From:
To: [DCAdmin](#)
Subject: Comment on planning application 2022/62/92081/E
Date: 05 July 2022 11:22:45

I have sent short message via the application website as an objection due to the need to update the transport assessment document. My full comments are:

Title Proposed Site Plan		Client Wharfedale Ltd.	
MWA Project Ref 6228	Scale 1:200	Original Paper Size @A1	Paper Orientation Landscape
Files Identifier Project	Originator	Volume	Level
WLLR - MWA - XX - XX - DR - A - 1001			
Revision	Role	Number	Revision
P6

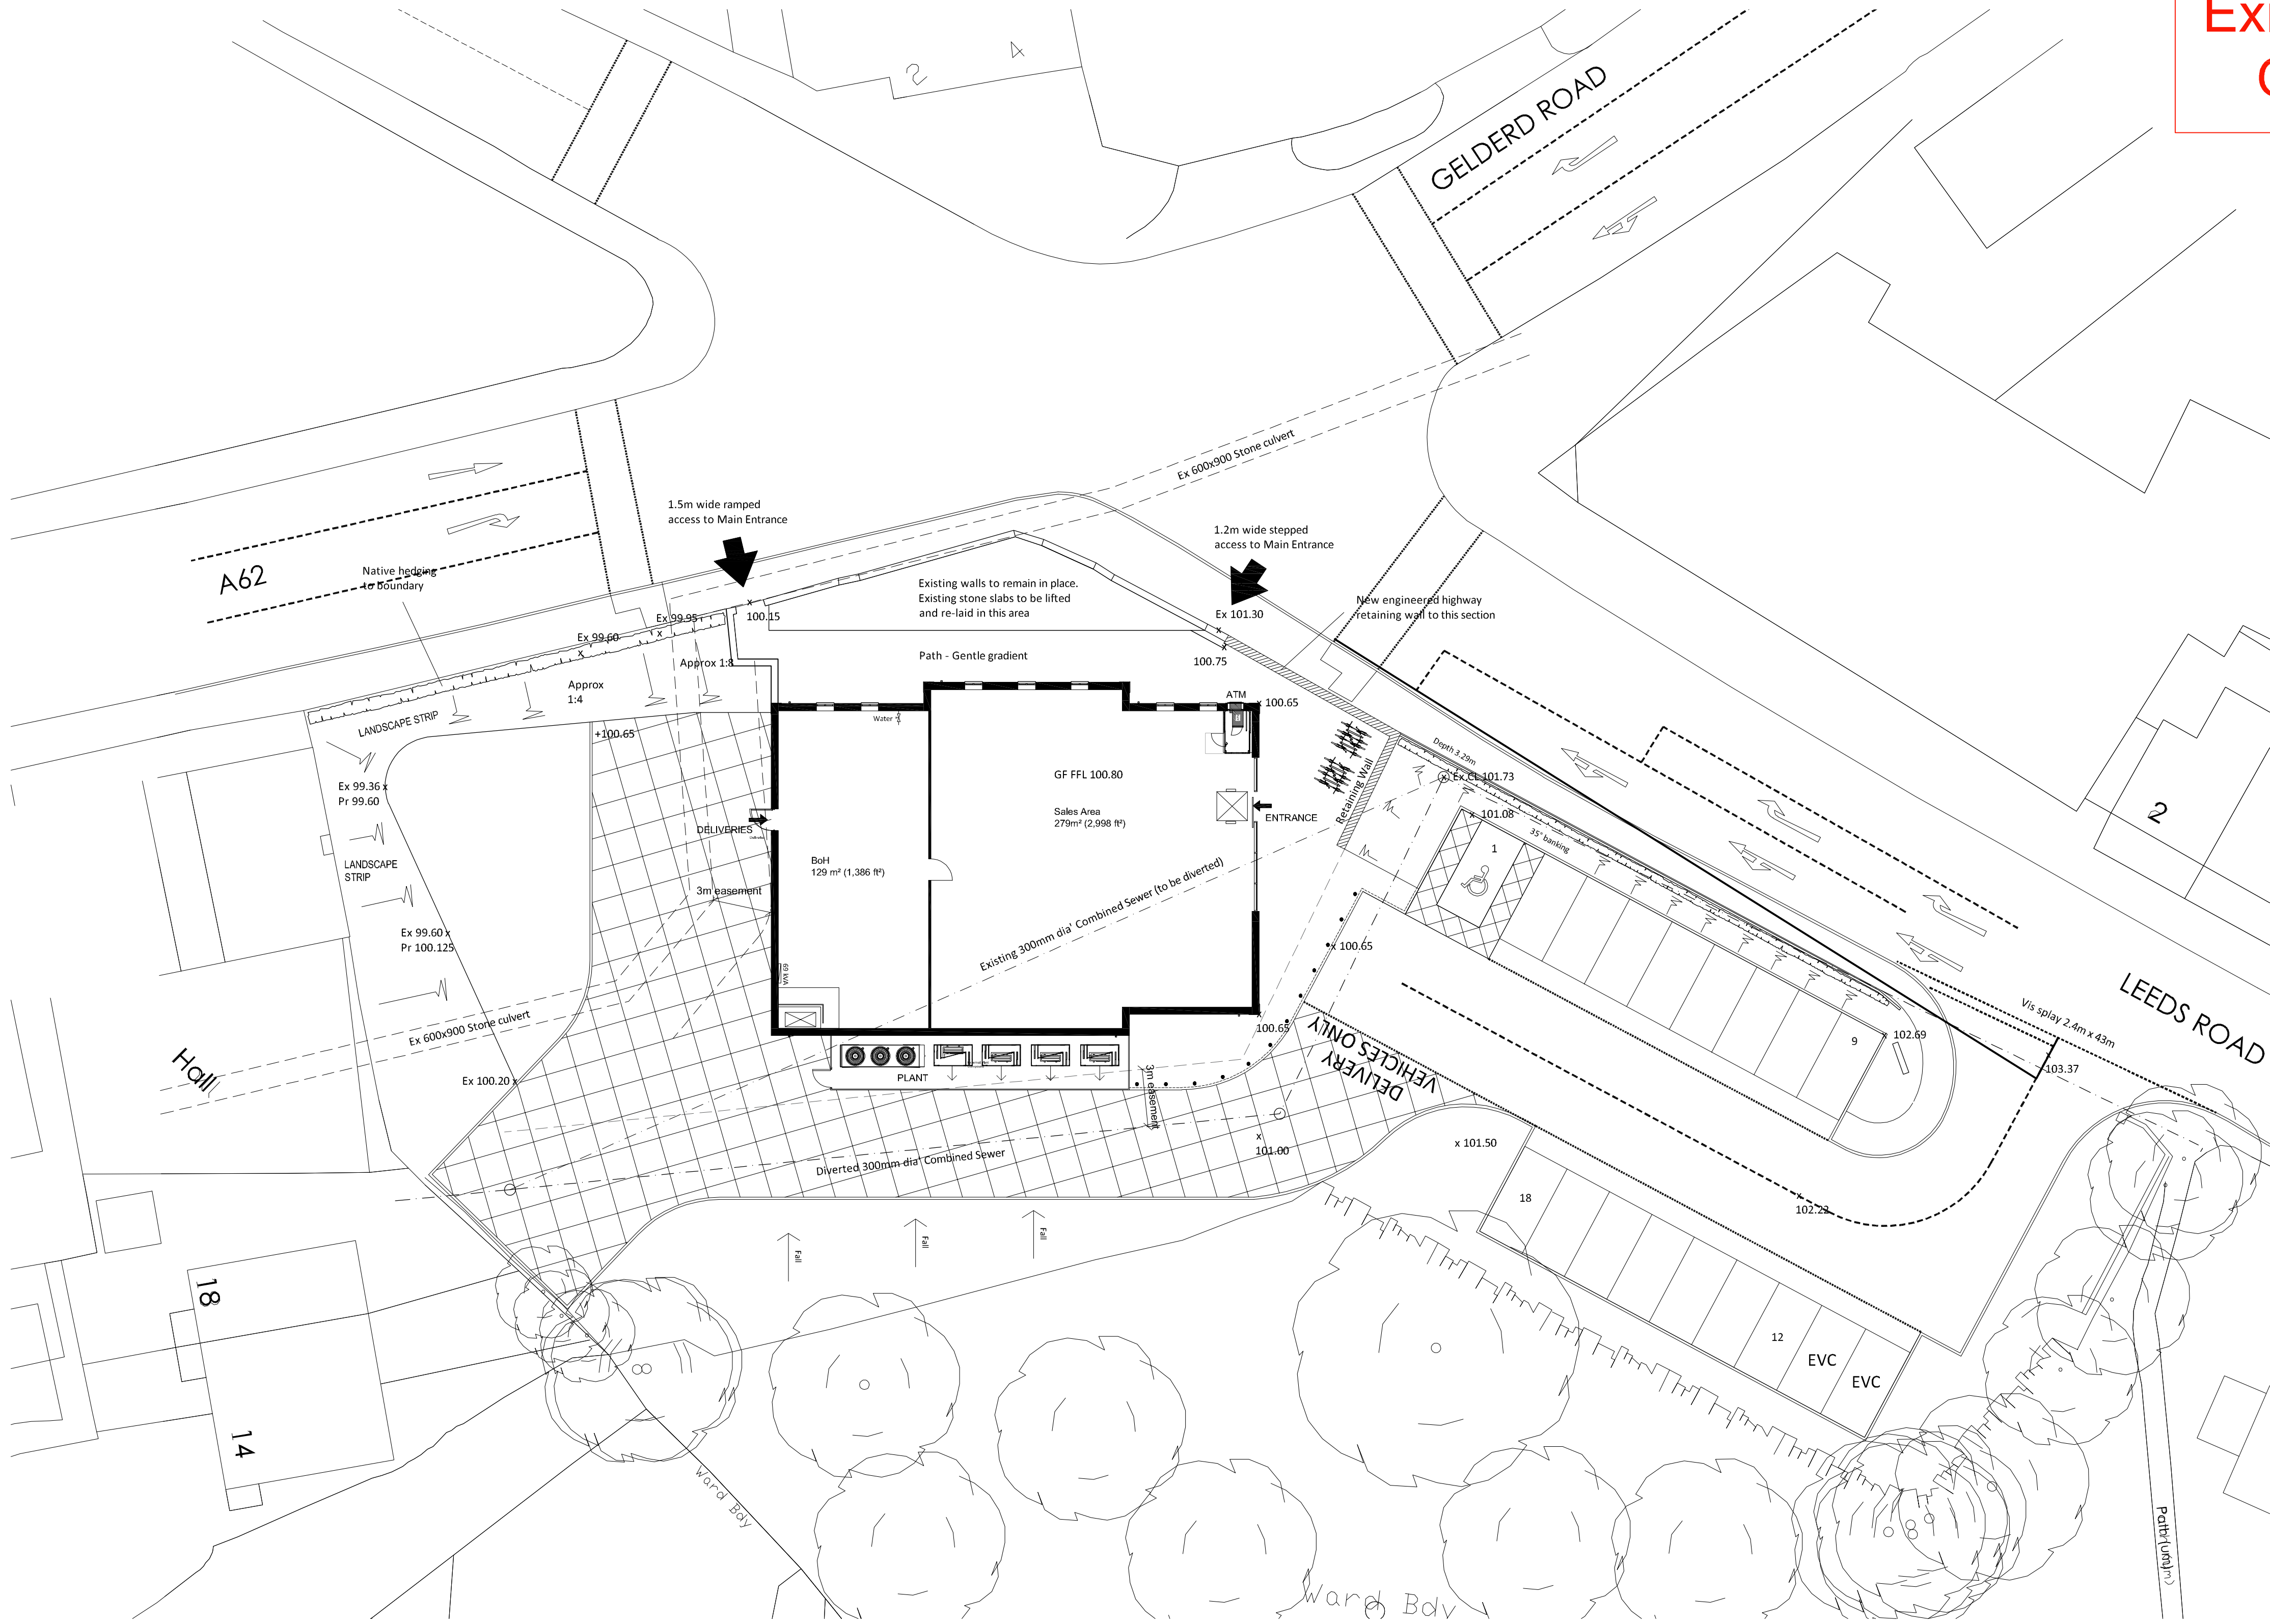
3) The proposed entry/exit is said to be 38 metres from the traffic light stop line on Leeds road. That is only for traffic going ahead or turning left. For traffic turning right out of Leeds Road onto Gelderd road, the stop line is 12 metres closer to the proposed entry/exit line (measured using the Acrobat measuring tool on the scale drawing). This is to allow for large vehicles space for turning left into Leeds Road from Gelderd Road. Traffic turning right onto Gelderd Road has to wait until traffic from Birstall has cleared. Vehicles leaving the proposed site to head onto Gelderd Road towards Leeds will have to cross the first lane and may block the going ahead lane.

4) The application should take into account that there is a bus stop adjacent to the proposed entry/exit point, on the same side of the road, as shown on the map in Appendix A, marked "Leeds Road Sovereign Close". A bus parked at the bus stop will severely hinder line of sight for traffic leaving the site, as would any large vehicle queuing up Leeds Road. The proposed 'Keep Clear' notification on the road may impact where the bus can actually stop.
